The Planning Inspectorate

Application by Gatwick Airport Limited for an Order Granting Development Consent for the Gatwick Airport Northern Runway Project

Request for further information

Surface Access Highways Plans – General Arrangements – For Approval

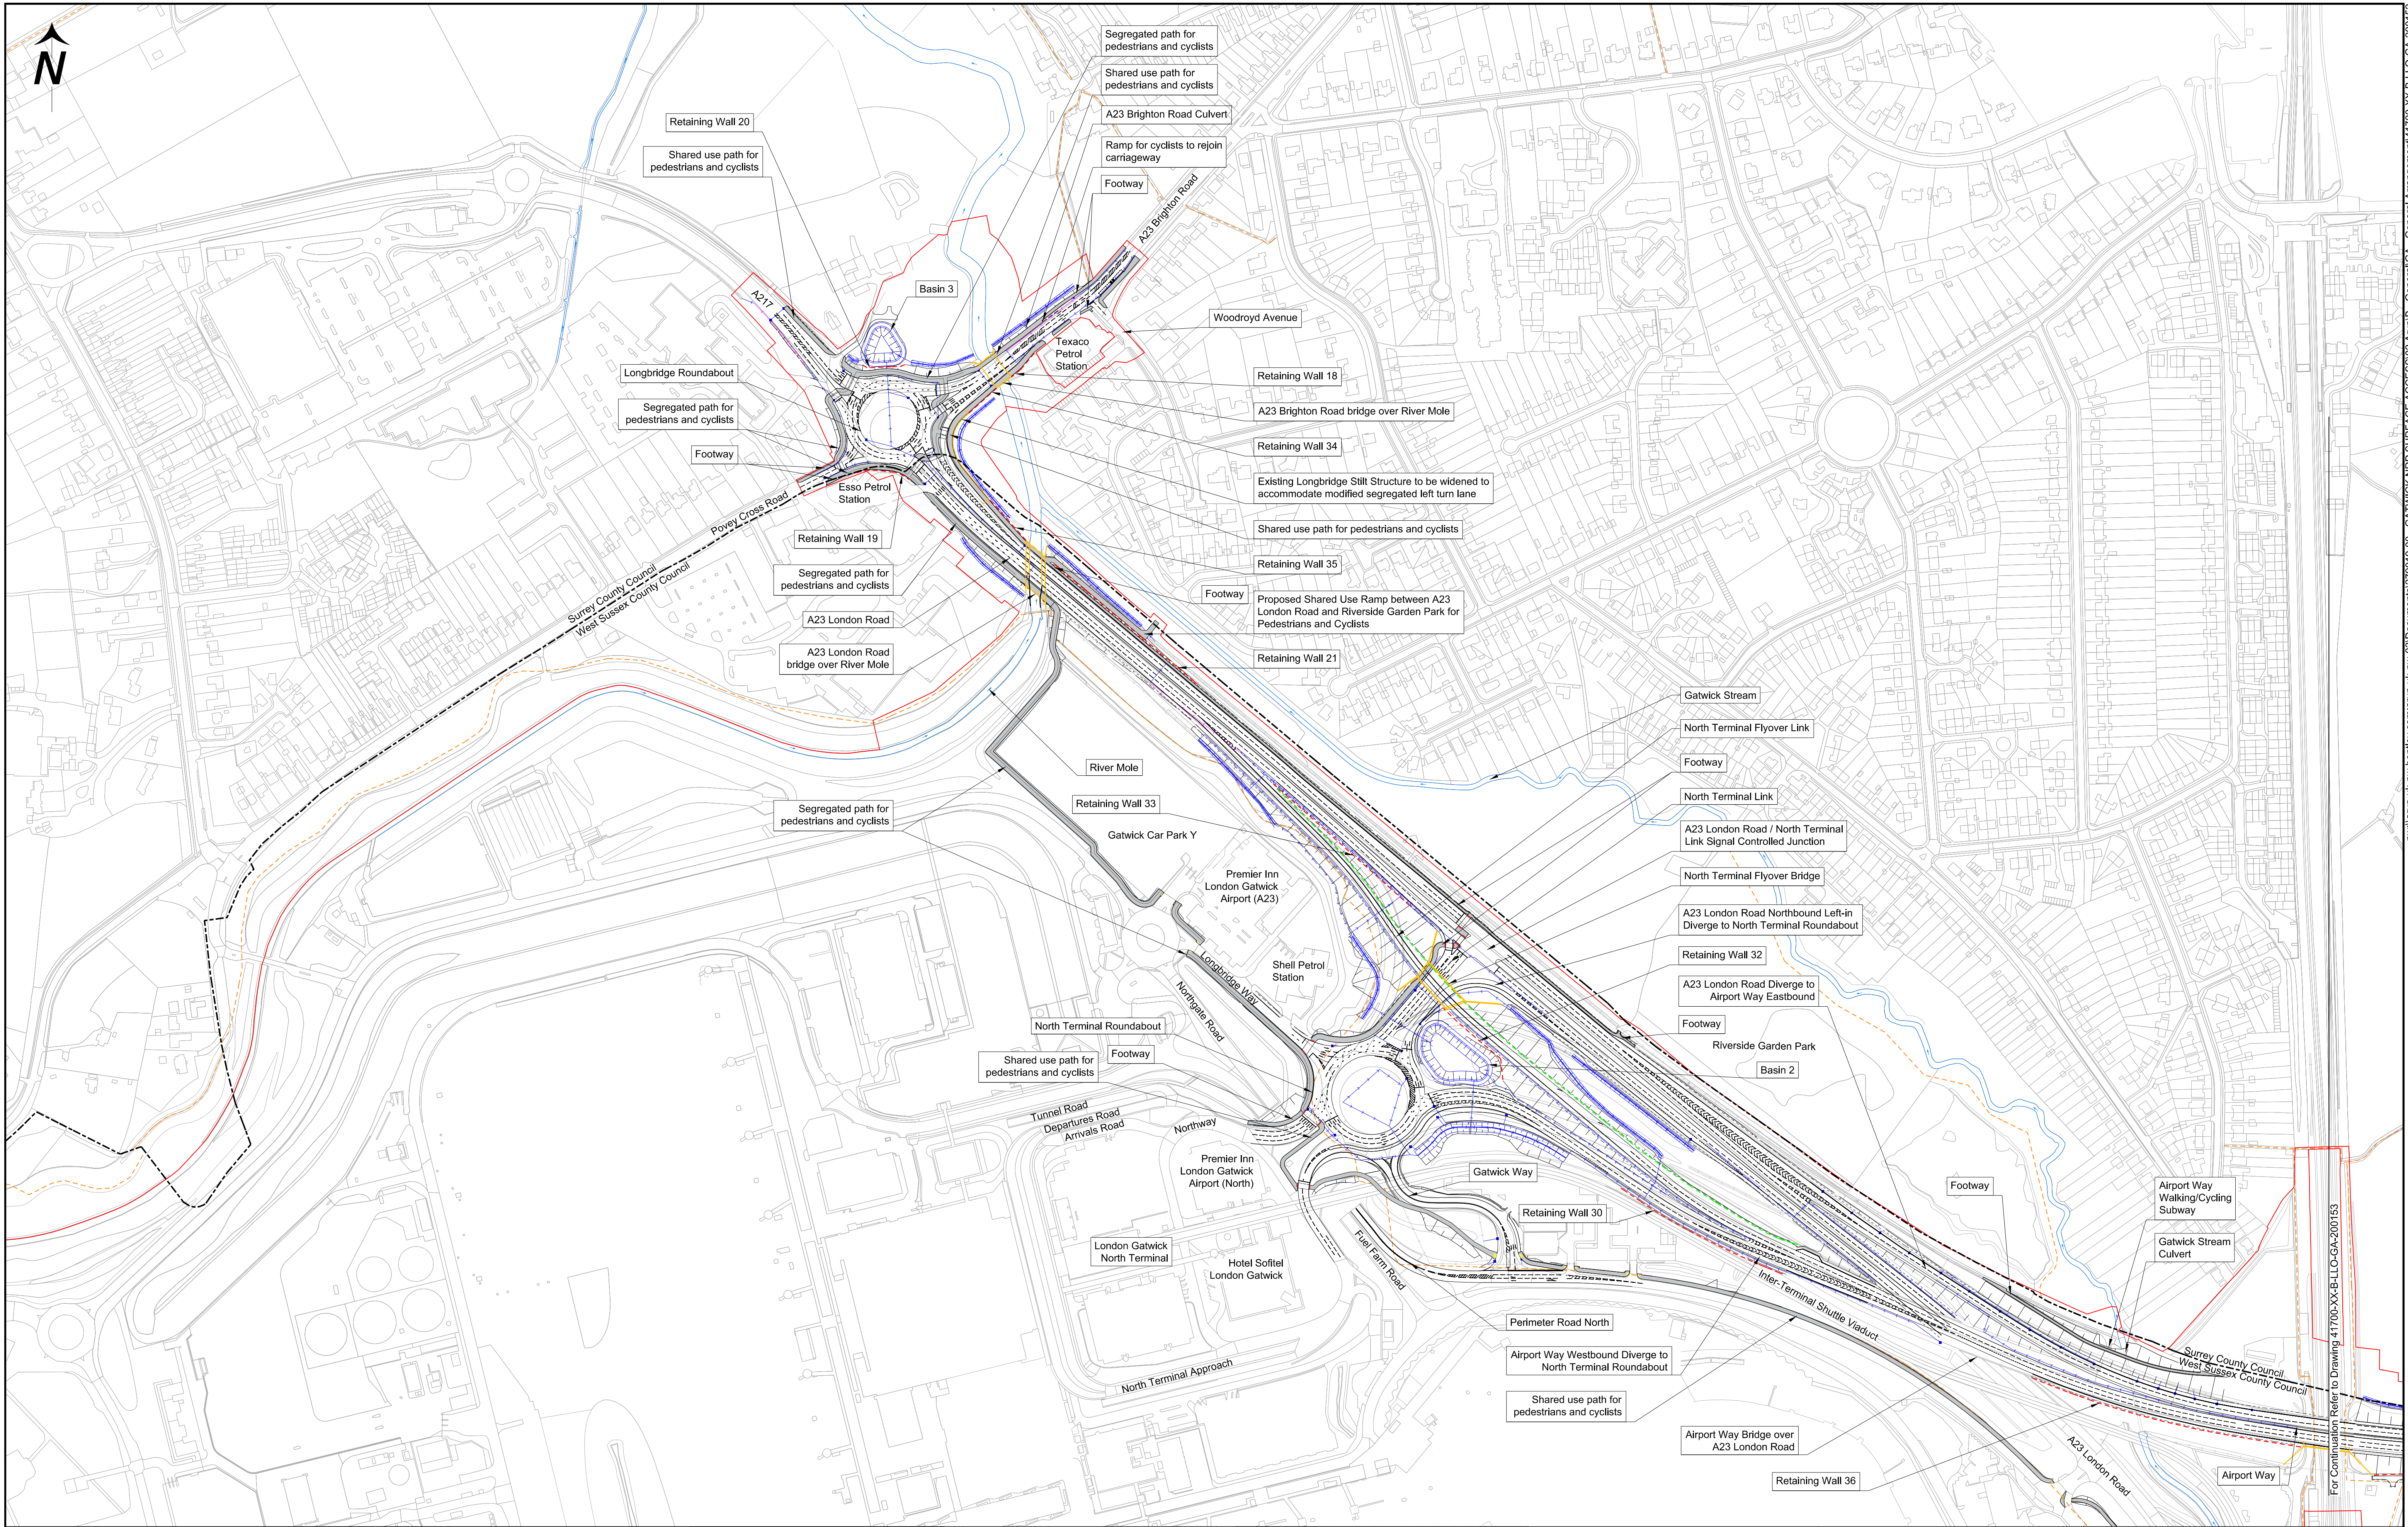
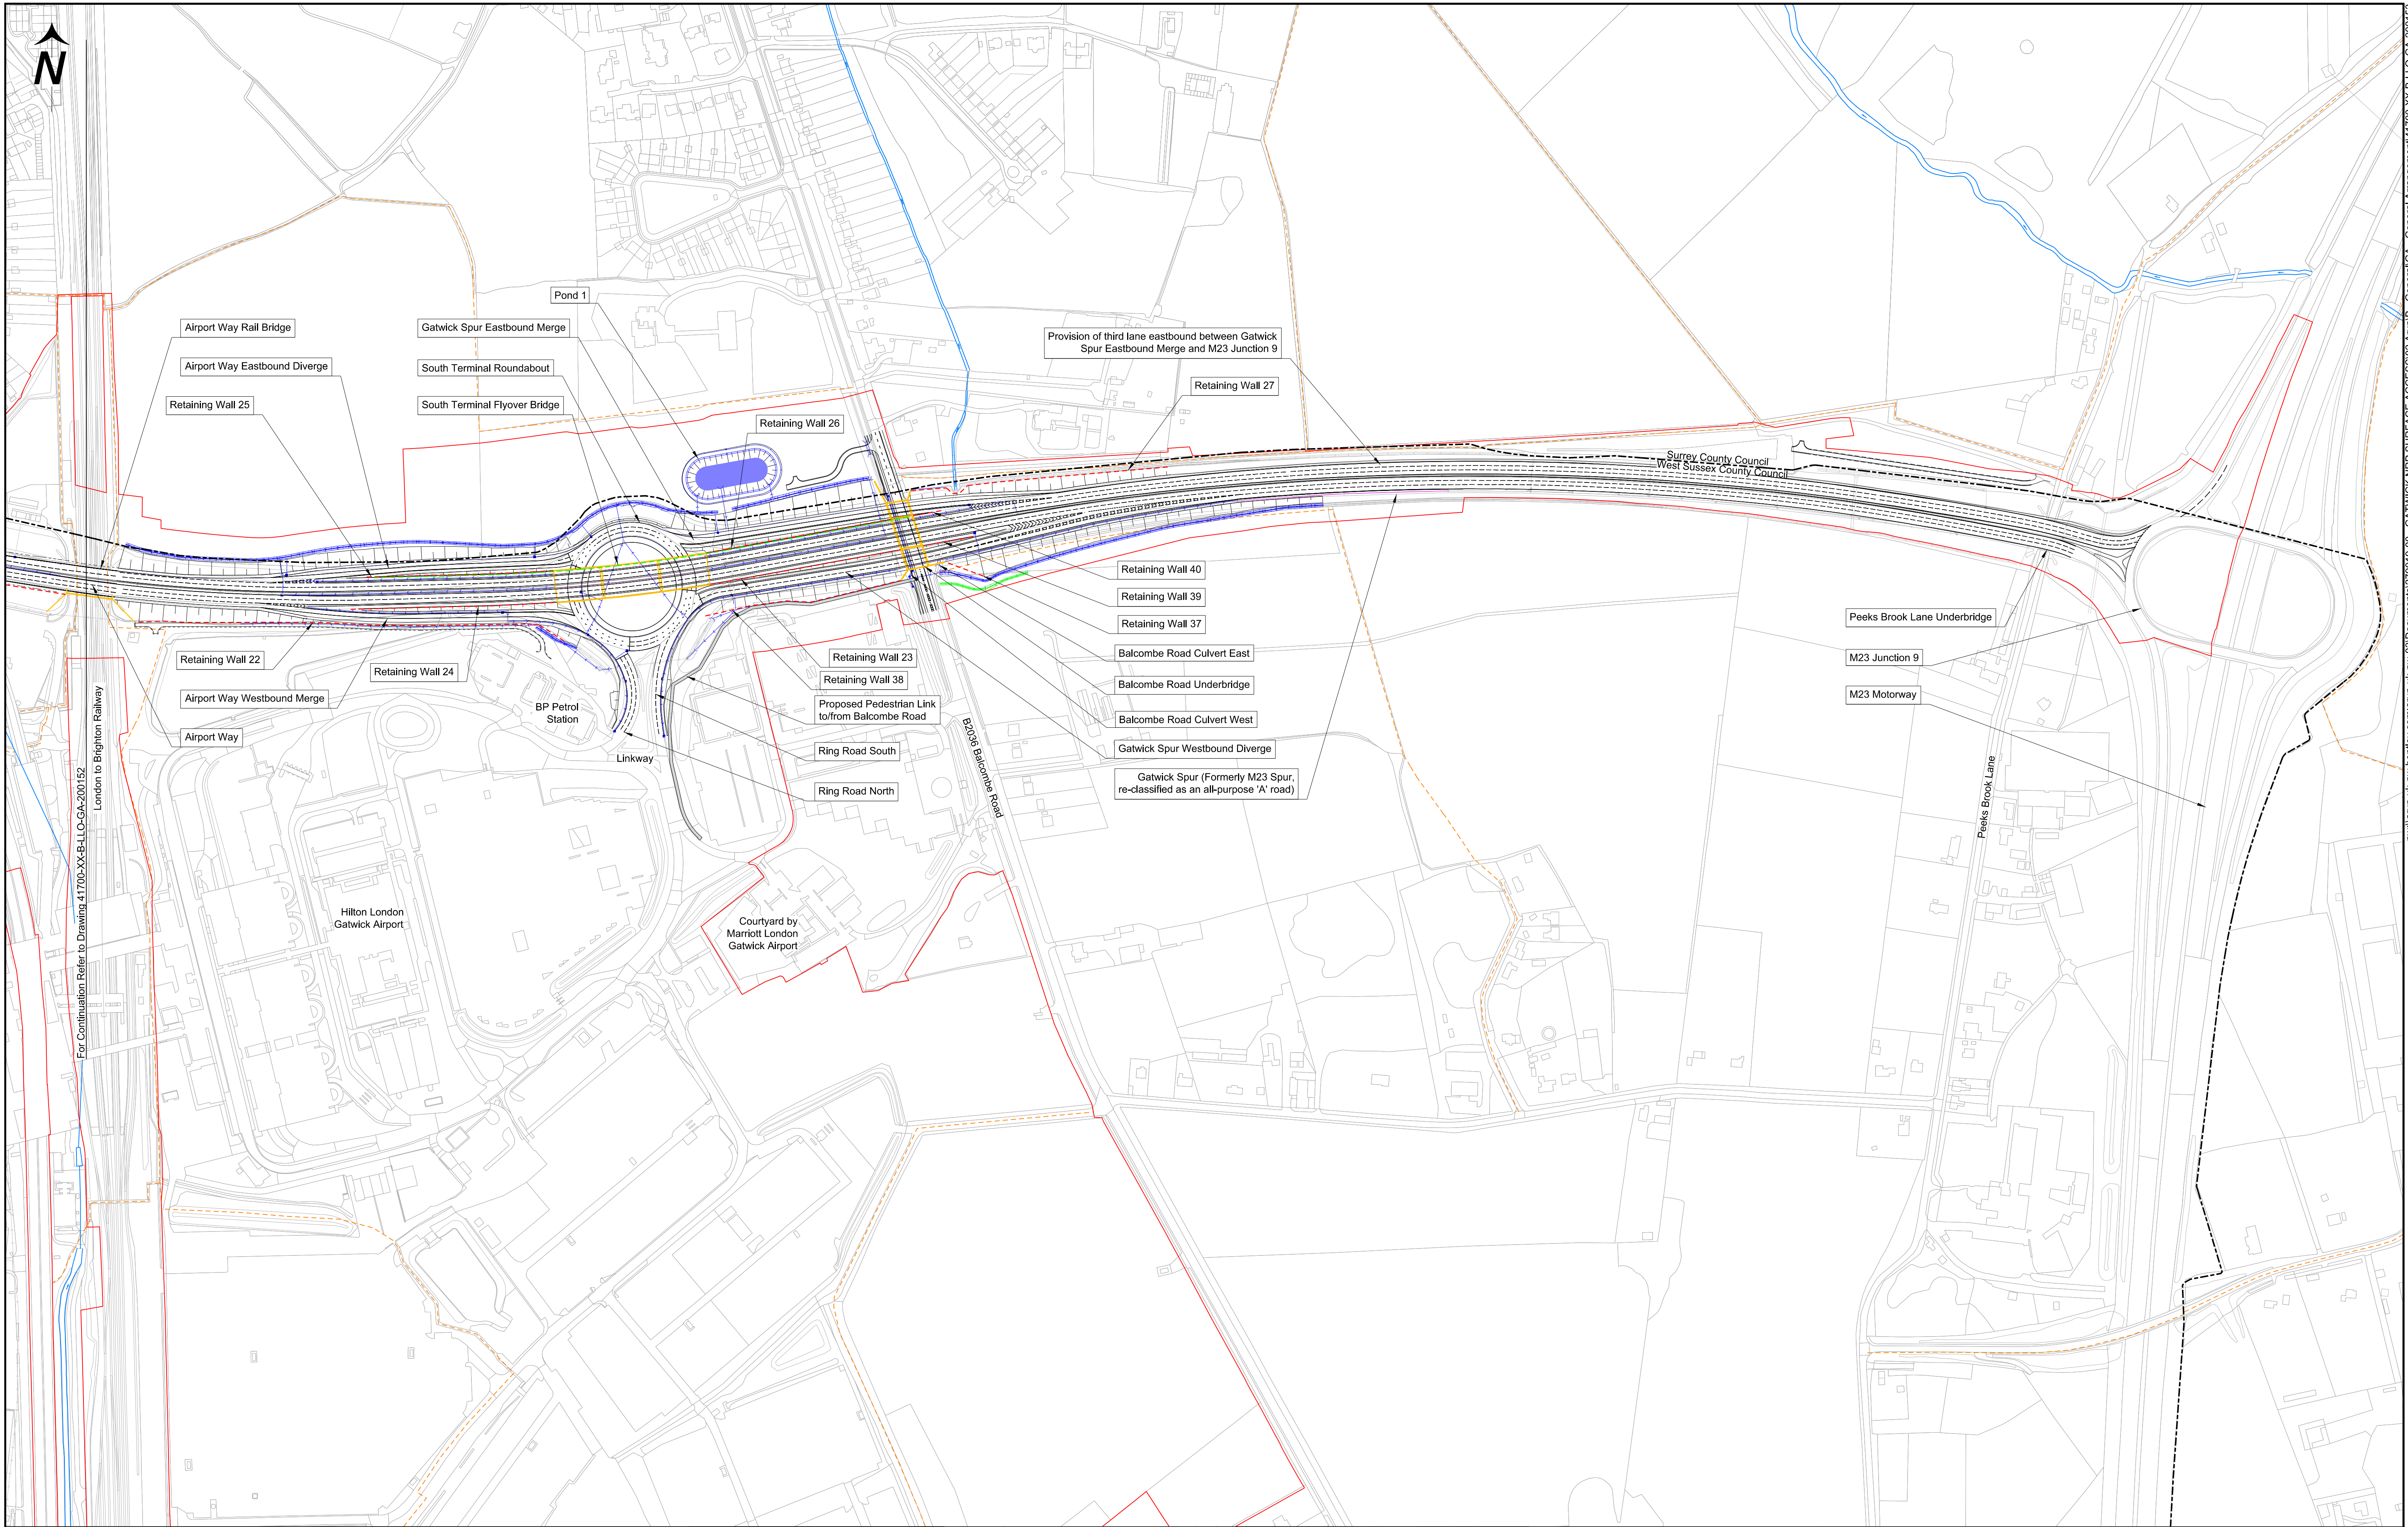
To assist in the Examination, the ExA requests that the Applicant supply a set of scheme drawings clearly showing the existing OS 1:2500@A1 (or equivalent) map base. Currently the ‘Surface Access Highways Plans - General Arrangements’ [[APP-020](#)] have a very light grey existing topography layer background making identifying locations of certain

proposed features difficult when the existing layer is obscured by the much bolder proposed features, including features like road markings, pipelines, etc.

New Highway Layout Outline Plans are required to assist in the interpretation of the proposed scheme and its elements within the existing topography. The ExA requests such plans show the following in different colours:

- All existing topography in black and annotated as to identifiable features.
- Existing roads and footpaths hatched or shaded to enable identification within proposed outlines and any shading.
- Order Limits.
- Outline of proposed roads, active travel routes and extents of cutting and embankments.
- Light shading of proposed bridges/ viaducts.
- Light shading of proposed culverts/ tunnels.
- Any retaining walls.
